Re: 16 Montrose Avenue – 176 H008 & 009 – R-5 – rebuild three story deck – permit #2011-05-1105

I have finished my review of your permit application to replace the three story deck at 16 Montrose Avenue. At this point I must deny your permit.

SHEET TITLE:  
PLANS AND ELEVATIONS

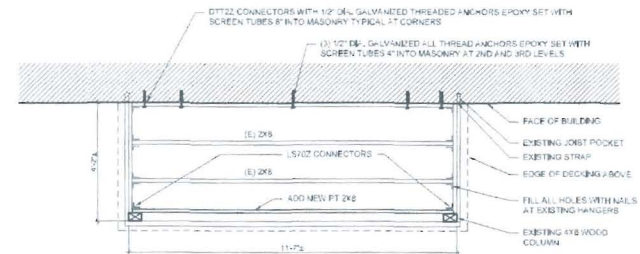
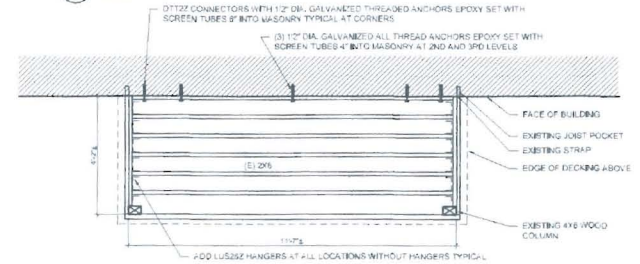
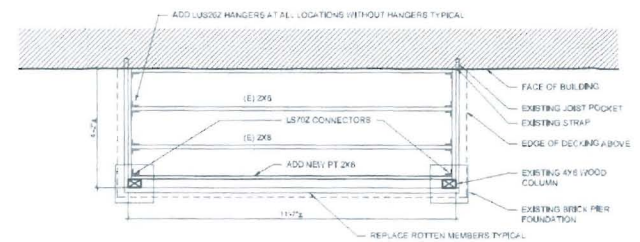
16 Montrose Street is located in the R-5 residential zone. The minimum required rear setback is twenty feet and the minimum required side setback for a two and half story structure is fourteen feet [section 14-120(d)(2 & 3)]. The plot plan shows a distance of 2'2" from the edge of the deck to the rear property line. The side setback is not given, but it appears to be less than fourteen feet.

When we receive an application to replace a structure that is nonconforming, we look to see if the structure was originally permitted. I have researched our files, and I cannot find a permit to build a five foot by twelve foot three story deck. I also looked at the pre-1957 assessor's card to see if the three story deck existed before 1957, but it did not. If the decks were not permitted, they are not legal. They must be removed to bring the property into compliance. You have thirty days from the date of the letter to do this. Our office will work with you to achieve compliance, but since there is no permit for the original three story deck, it needs to be removed.
